Recommendation Report for Works to Tree(s) on trees subject to a Tree Preservation Order (TPO)

REF NO: FG/113/20/T

LOCATION: 2 Phoenix House
Ferring Grange Gardens
Ferring
BN12 5HU

PROPOSAL: Crown Lift to 3m 1 No. Sweet Chestnut tree

T1 SWEET CHESTNUT

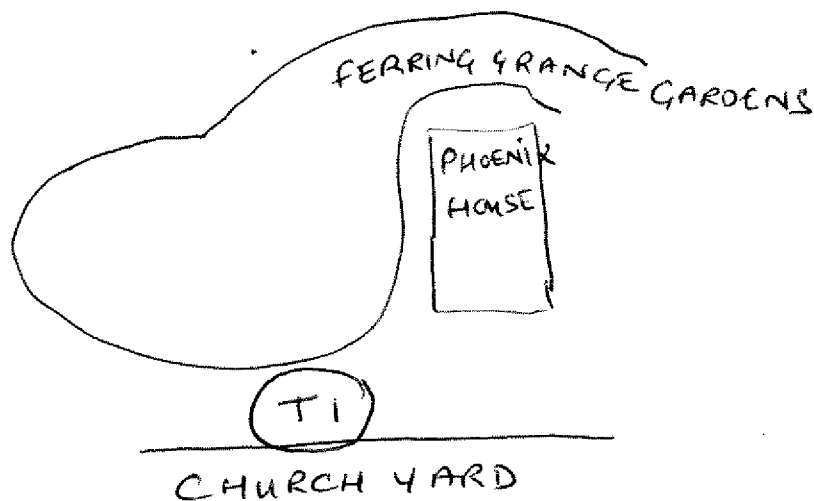
- The applicant seeks to provide 3metres overhead clearance on all aspects, which ought to remove/reduce only small diameter branches - so of limited consequence to tree health and form.

· It is located adjacent the churchyard site and so is both visible from surrounding properties and to those attending the church/cemetery. As such, it has public amenity value.

· The work proposed is justified on arboricultural grounds. This is a prominent tree which provides visual amenity and is to be carefully pruned to maintain reasonable enjoyment of residential property and with respect for natural tree form.

· I recommend CONSENT for this application, subject to the following conditions.

- 1 - Where whole branches are to be removed and final cuts made close to the trunk or branch union they are to be made as shown in Figure 2 of BS3998:2010
 - Where branches are to be shortened back the final cuts are to be made at the correct angle shown in BS3998:2010 and adjacent to a live bud or lateral.
 - Reasons: In the interests of the tree's continued health and vitality and to accord with current industry guidelines and sound arboricultural practice.
- 2 INFORMATIVE: The applicant should note that under Part 1 of the Wildlife and Countryside Act 1981, with only a few exceptions, it is an offence for any person to intentionally take,
